Engineers Comments Regarding Surface Water Drainage

Application Reference:	BE/40/22/PL	Reviewer Reference:	ADC/SB
Planning Officer:	Maria Tomalova	Date of Review:	15 June 2023
Site Name:	Former Bartons Infant School Romney Broadwalk Bersted PO22 9BH		
Application Description:	Demolition of former school building and erection of 20 No. new dwellings and associated car parking, cycle parking and landscaping. This site is in CIL Zone 4 (Zero Rated).		
Assessment Number:	3 of 1

Application Reference: BE/40/22/PL Site Name: Former Bartons Infant School Romney Broadwalk Bersted PO22 9BH			Initial Issue Date: 15 June 2023 Issue Date: 12/07/2023		
	ADC Drainage Comments	Applicants Response	ADC – 21/04/2023	Designer – 24/05/2023	ADC - 12/07/2023
Summary and Recommendation: No objection – request conditions (PCENG2, PCENG3, PCENG4 and ENG1)					
	Condition Number:

filename: w:\1444 wsc - lovell\jvhed\cad2 north bersted\stage 3- p06\1444-hed-dr-02-002-003 hard & soft landscape plans p06.dwg, printed on:2023-07-20 on iso full bleed a3 (297.00 x 420.00 mm) @ 100% of original scale

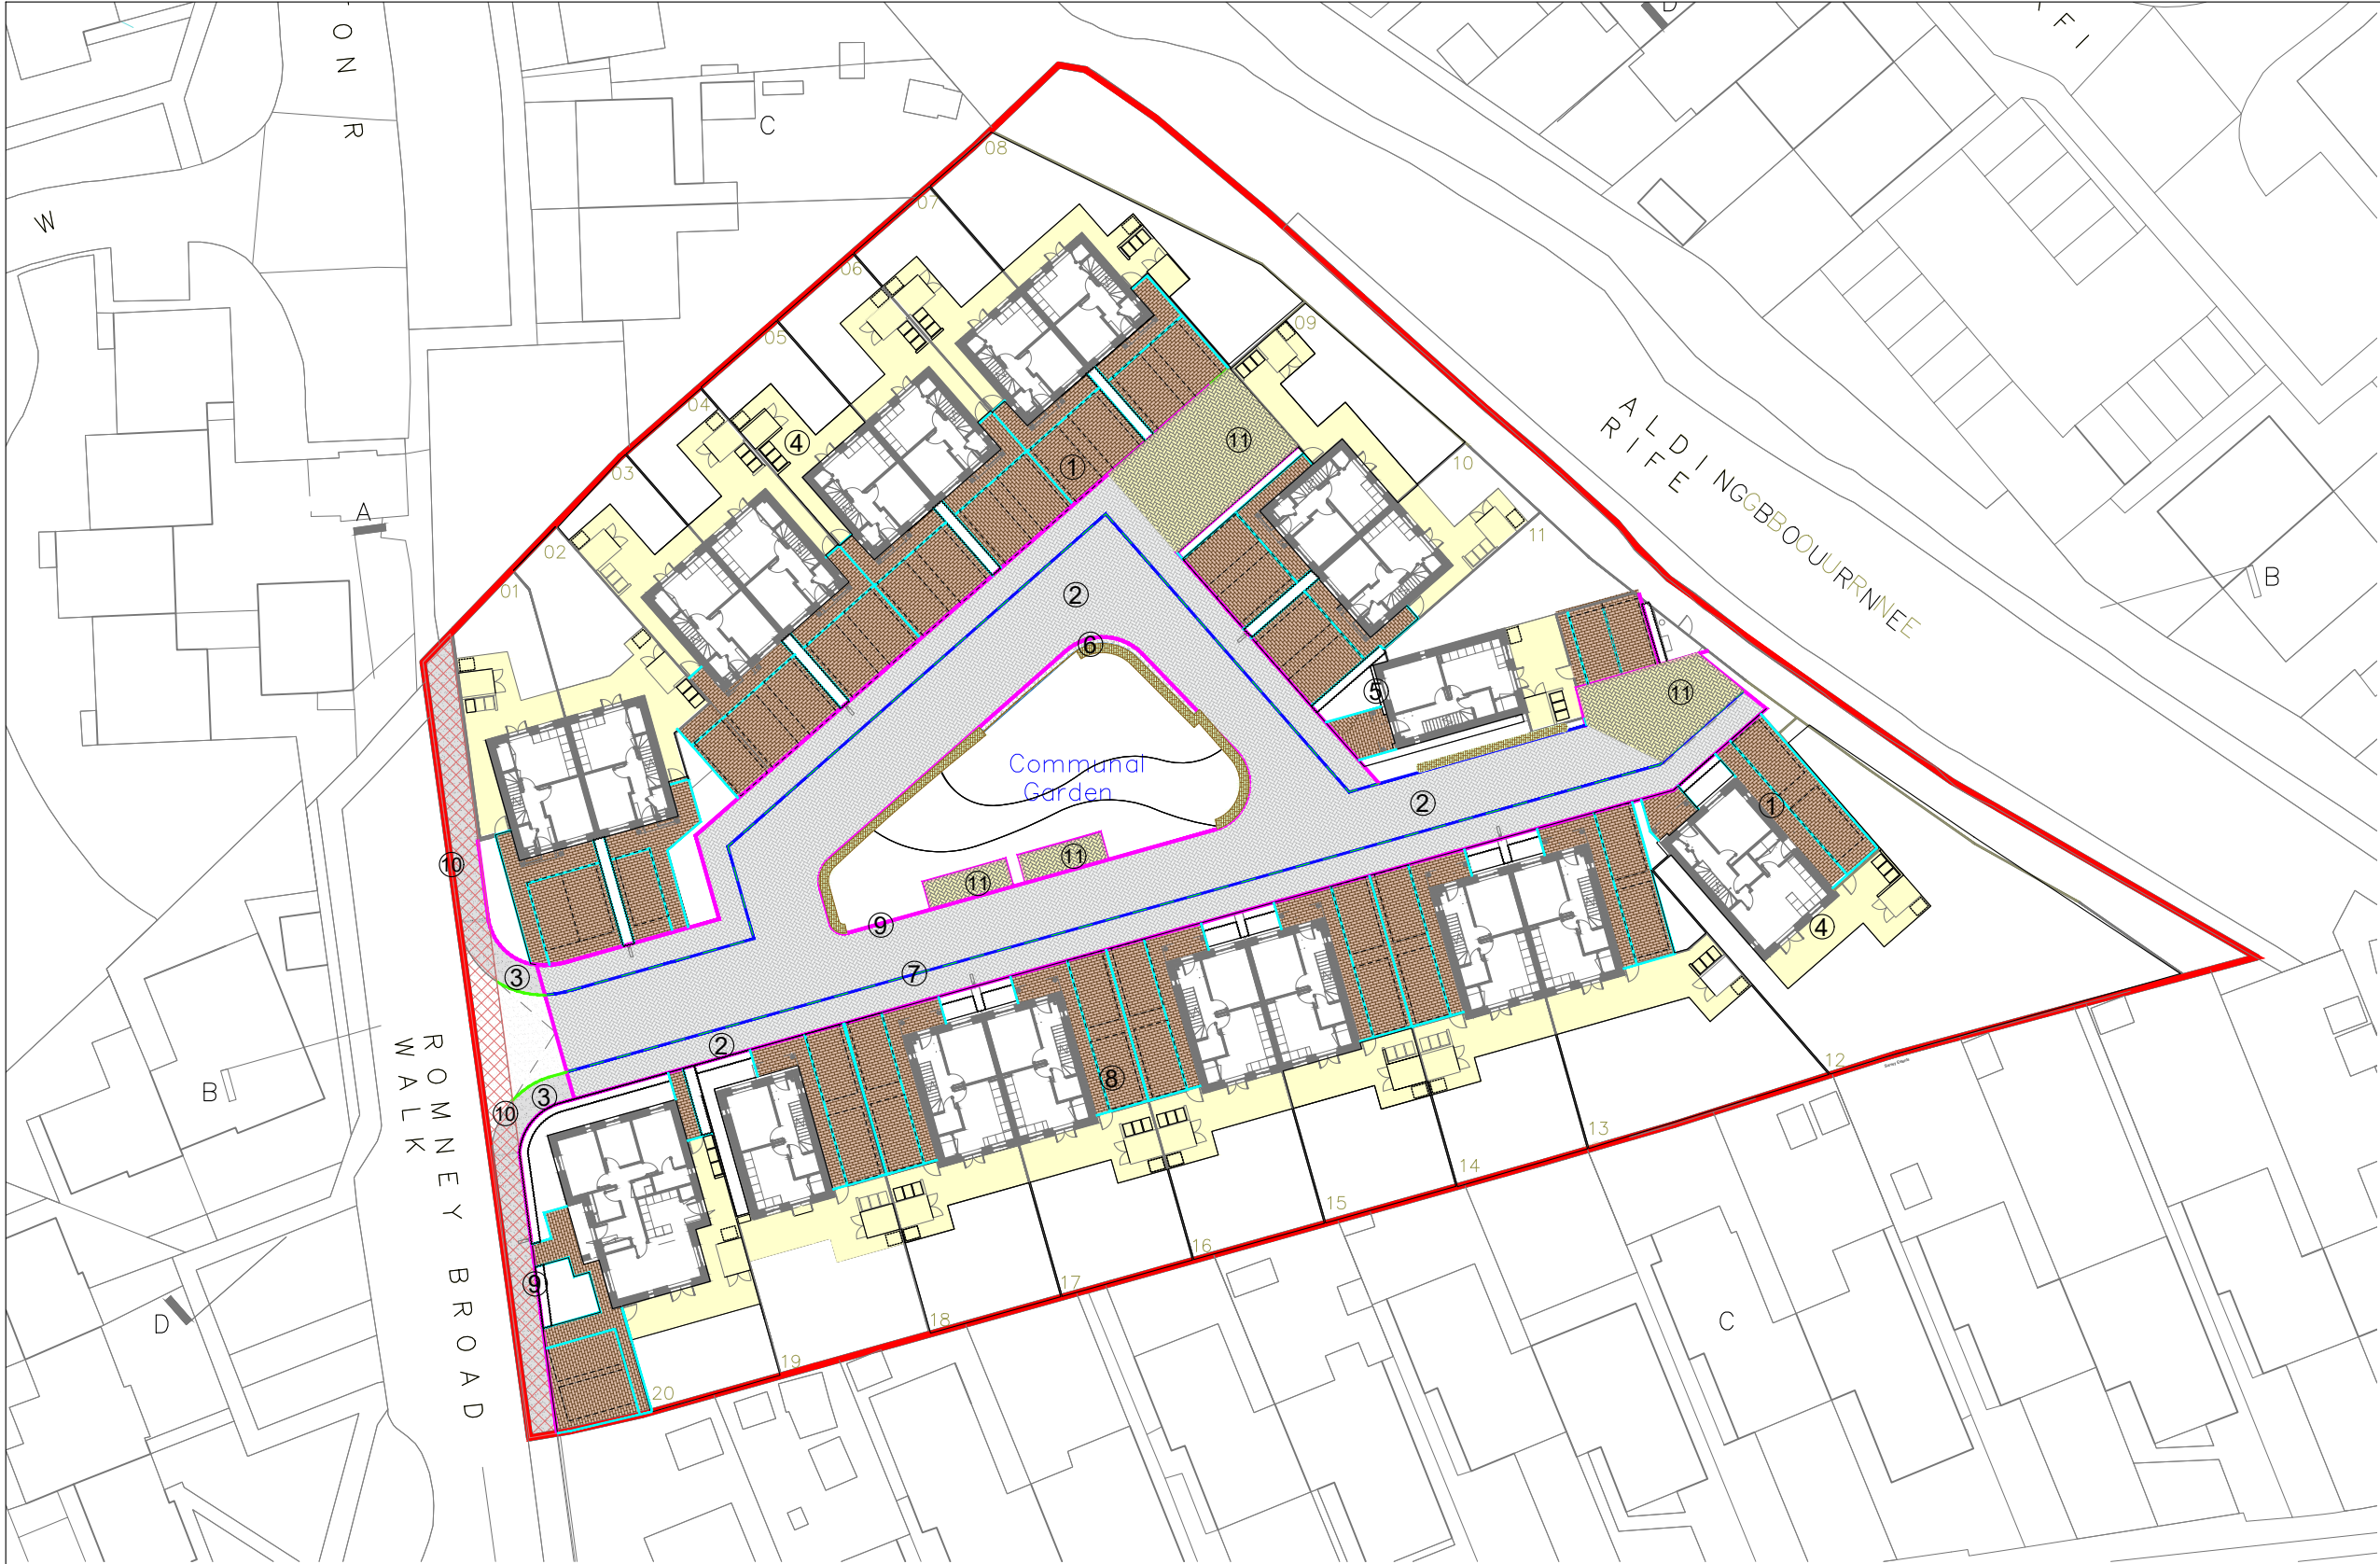
3.			The current landscaping design proposes one Red Oak tree and 8 Himalayan Birches planted directed over the area where the attenuation tank and storage blanket are proposed. This is inappropriate – drainage infrastructure and trees must not conflict. Tree roots have the potential to damage pipes, the tank and blanket liners which can cause groundwater ingress, loss of capacity and connectivity. Furthermore, the location of substantial drainage apparatus within 0.3m of ground level is likely to inhibit the growth of the proposed trees – please	We have coordinated with the landscape architect and the trees are now away from the tank. The tree pits eat into the storage blanket and we have taken this into account within the storage calculations. Please refer to the updated landscape architect's information (attached in the WeTransfer link) for details of the tree pits showing root barriers which will prevent ingress of roots into the adjacent drainage infrastructure.	I am satisfied that the proposed trees (in tree pits as detailed) will not impact the surface water drainage. Landscaping must be in accordance with the latest plans as listed in my consultation.

consult the landscaping officer in this regard.		
4.			There also appears to be a proposed Quercus Rubra (Red Oak) located directly over the proposed outfall pipe east of plot 11. It is likely that this tree will need to be removed or relocated in the landscaping proposals.	This is now shown moved away from the outfall on the updated Soft Landscape Plan included within the WeTransfer link.	OK, updated plans now show this tree moved and all trees removed from the watercourse easement. Landscaping must be in accordance with the latest plans as listed in my consultation.

10.	We require the fences to be at least 3m from top of bank, between the development and ancient watercourse, to ensure that the proposals are in accordance with our land drainage byelaws. This easement should be delineated and confirmed on the drainage layout plan. From the information provided it appears that a 2m easement (approximately) has been provided for access and maintenance of the watercourse at present. It is recognised that no buildings are located within 5m (as is also required).	We have clarified the location of the top of the bank of the watercourse and shown a 3.5m easement to a relocated fence line location on amended drawing 11642/1601 rev P5 appended.	OK thank you. The same easement will need to be shown on all proposed site layouts and landscaping plans going forward.	Please see Landscape Architects drawings attached in WeTransfer link.	OK – thank you point closed.
